Ground Floor Plan
As Proposed 1:100

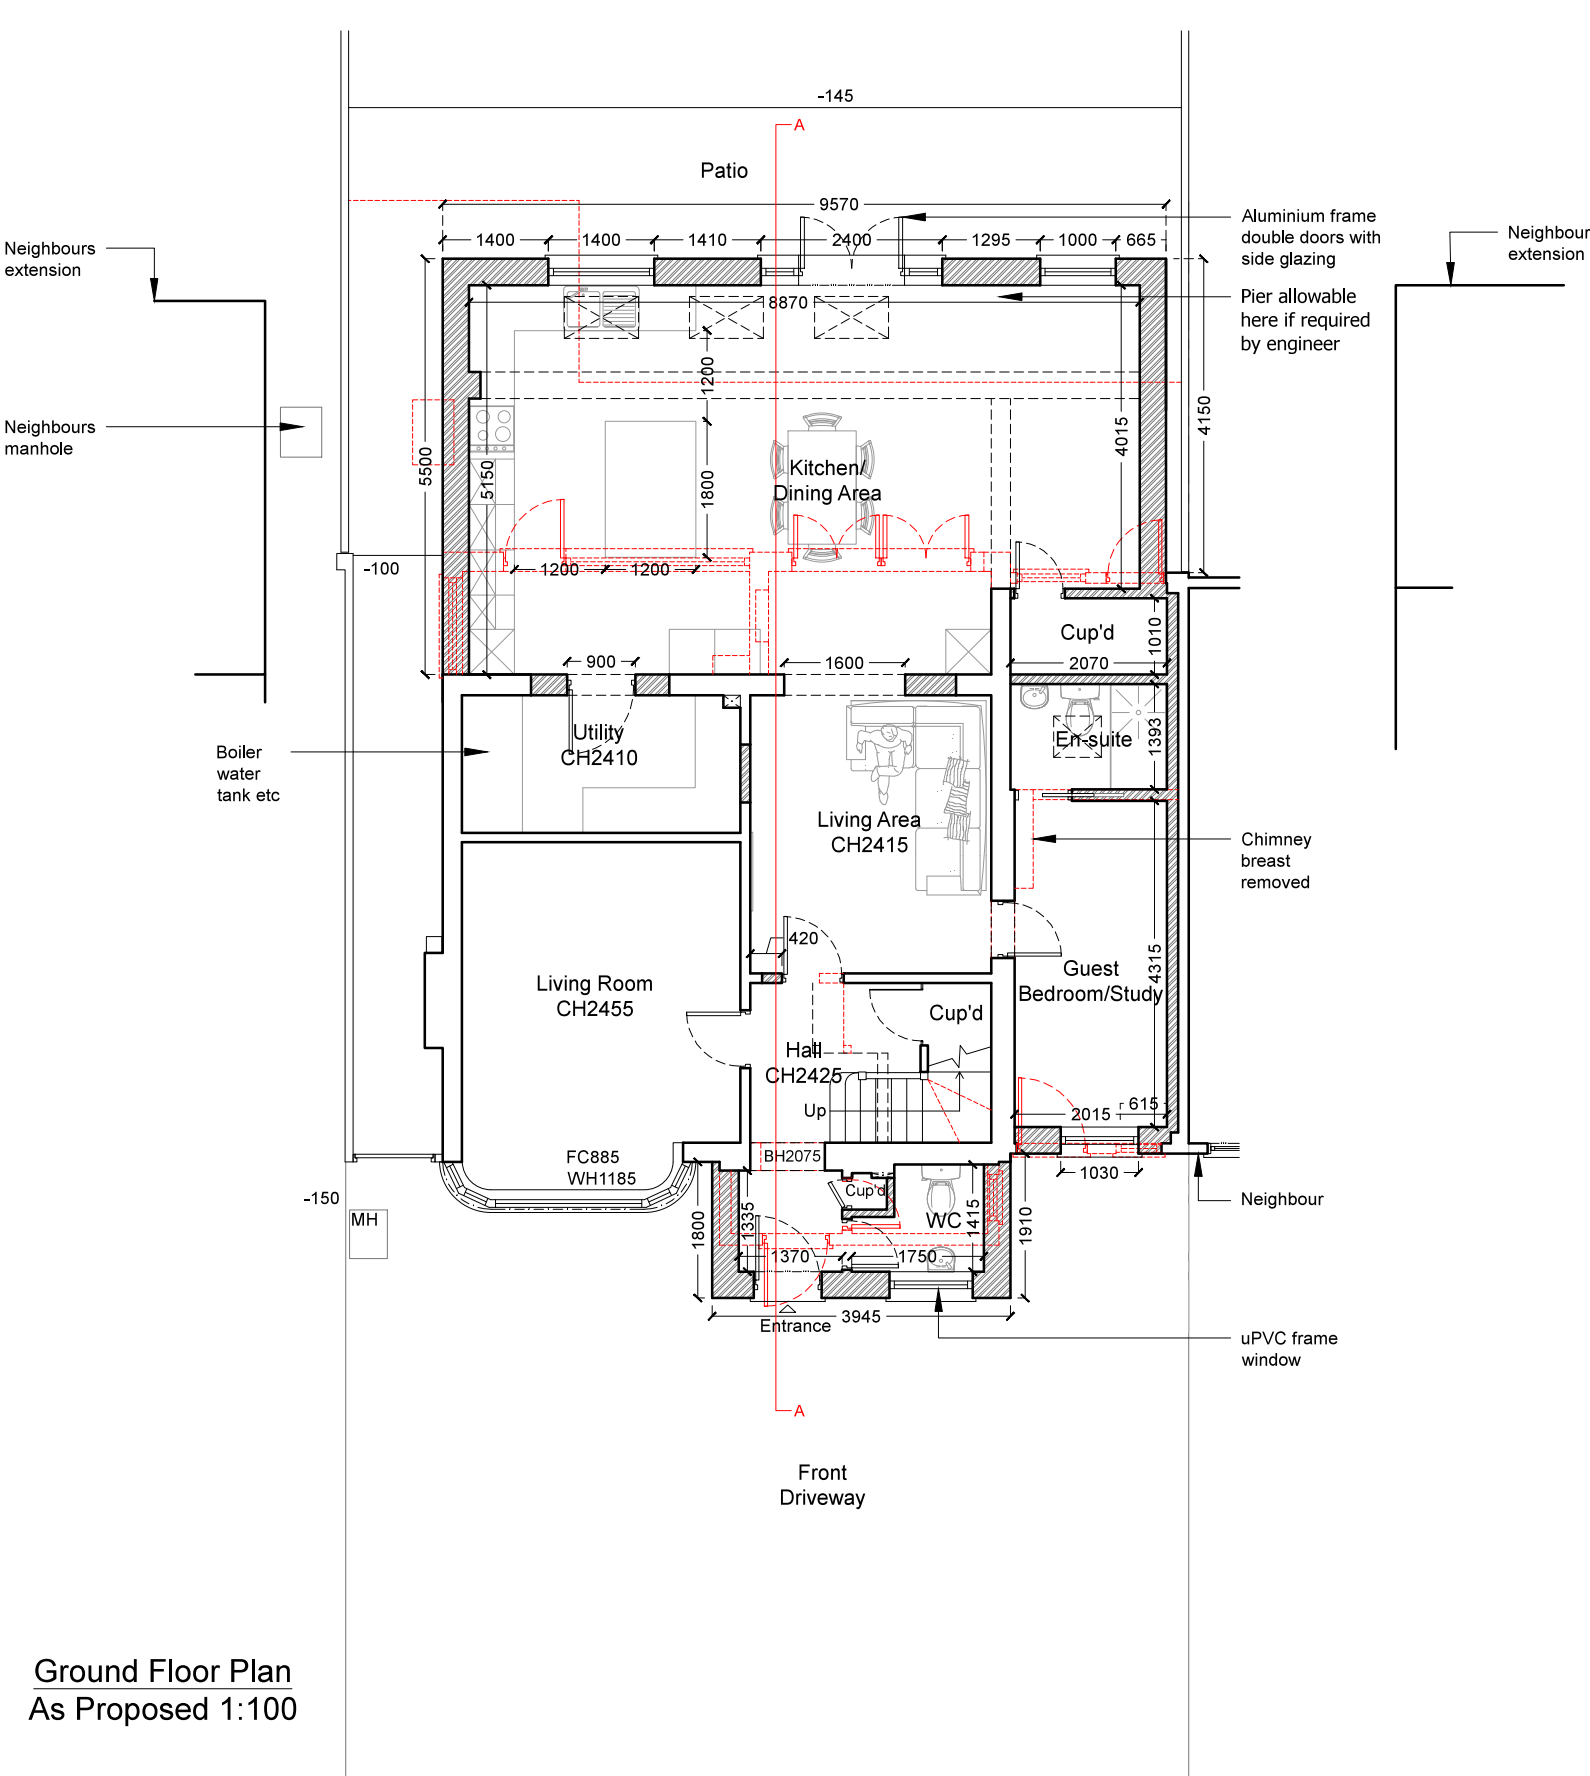
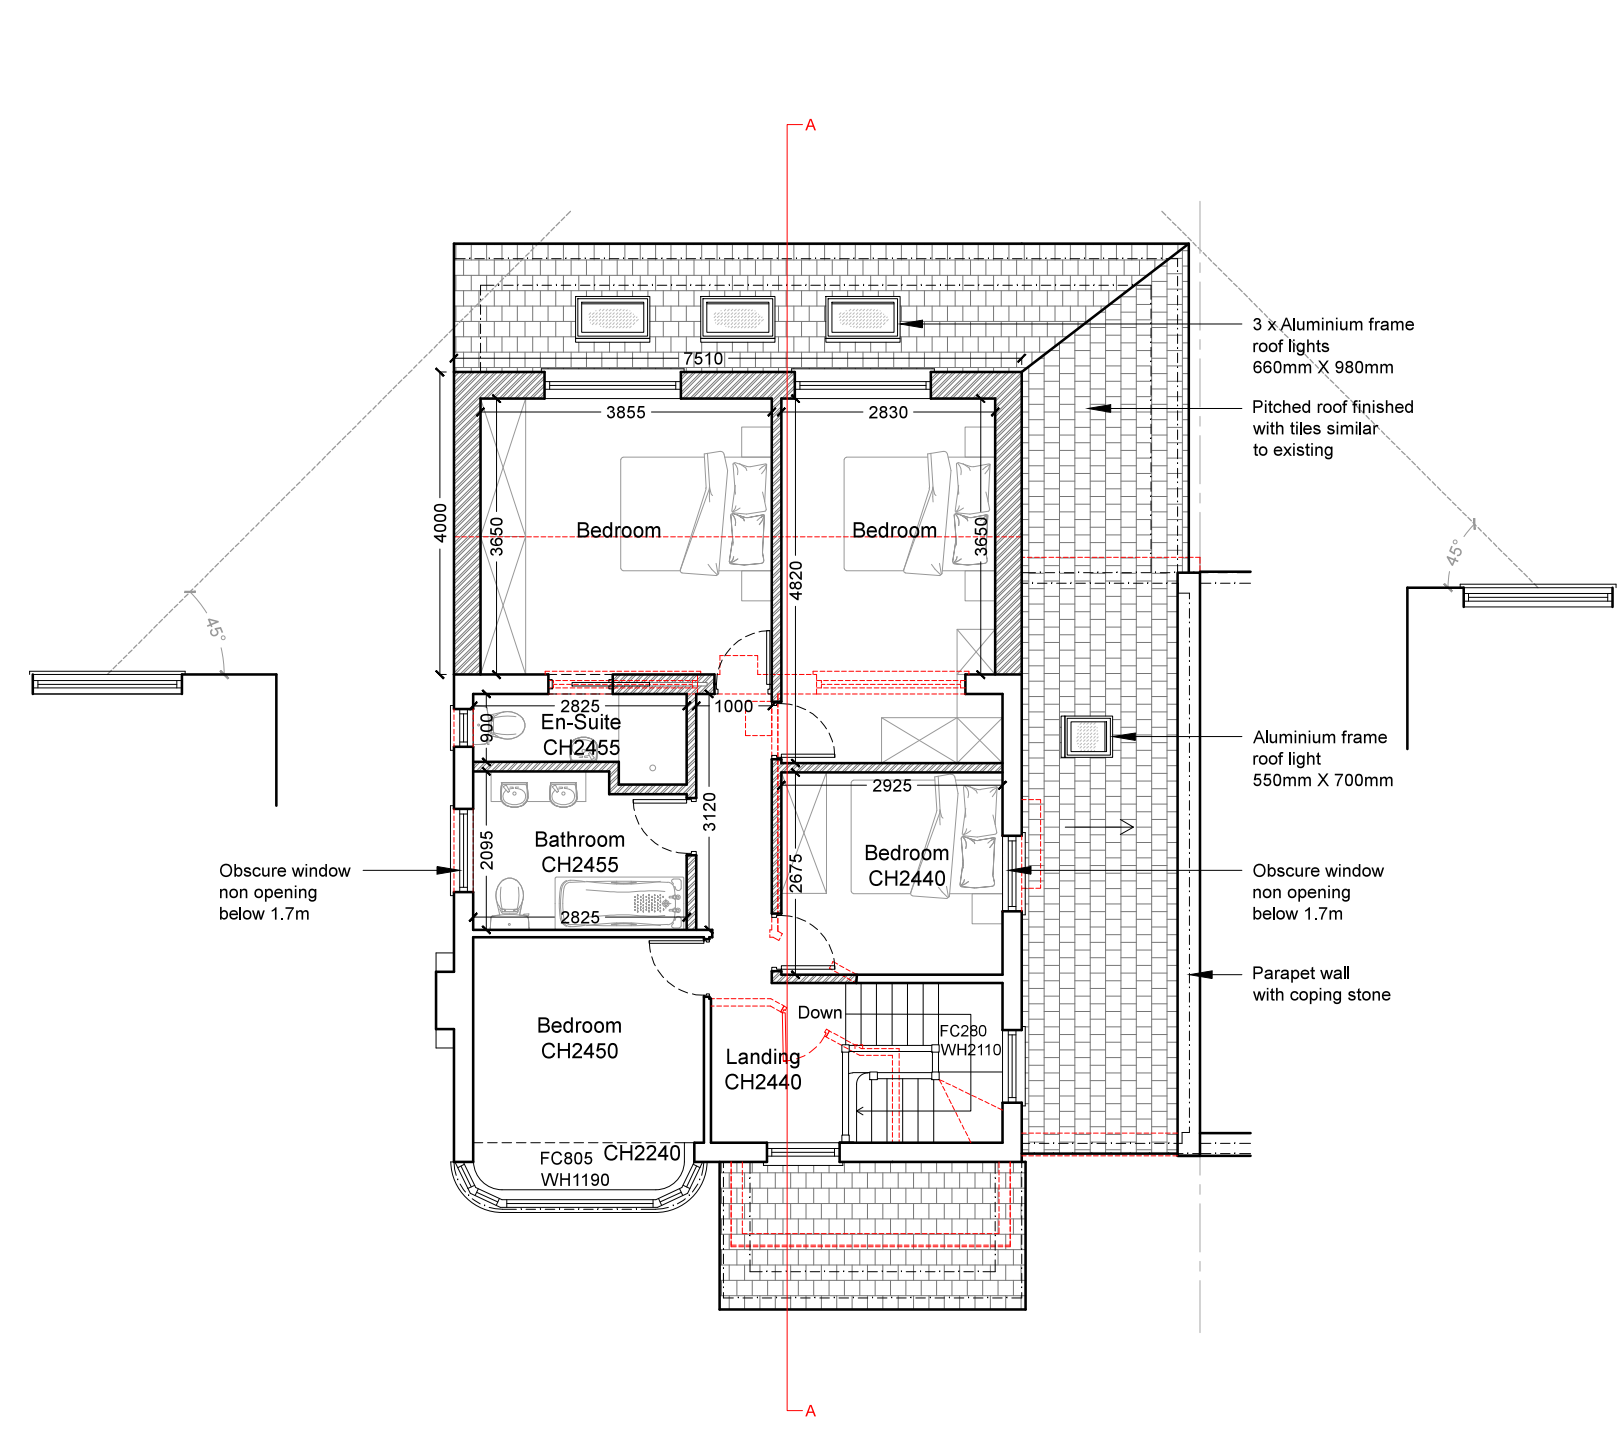
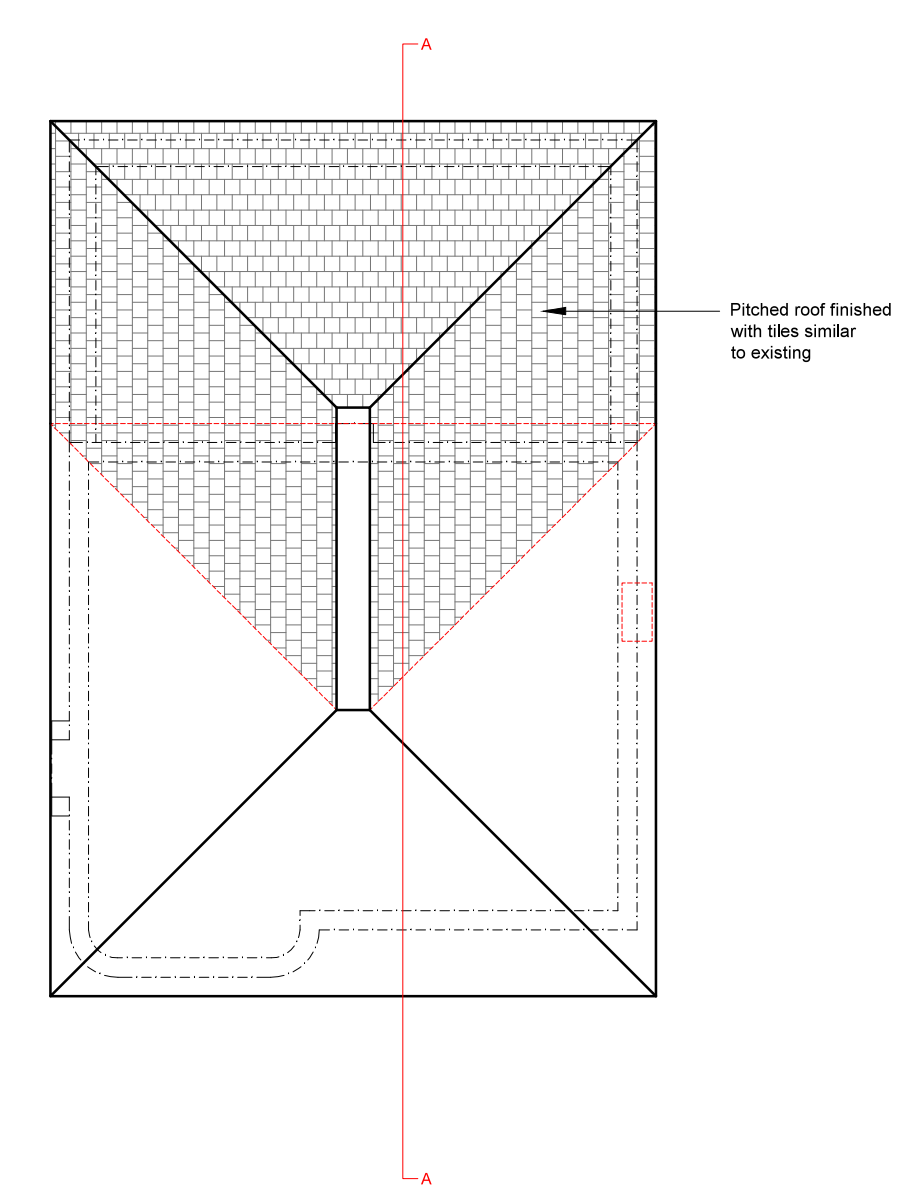
The ground story extension is proposed inches from my eastern boundary along the full length of my conservatory at the rear of my house, and as such will significantly delay or cut out entirely the low morning sun in winter. This conservatory is a room I make a huge use of - currently it is my home office, but in winter it is also full of germinating seedlings and cacti, both so desperate for light at these northern latitudes. More practically, the sun is a highly effective zero carbon heater on cold bright winter mornings.

The second story extension, which extends nearly as far will delay the sun at all times of year with similar impact.

I would ask that the design be reconsidered, and would hope that the rearward extent of the proposed development be reduced. Significantly shortening the proposed first and second stories would address my concerns. Stepping in the proposed ground floor so its western edge is under the western edge of the second story extension would also help.
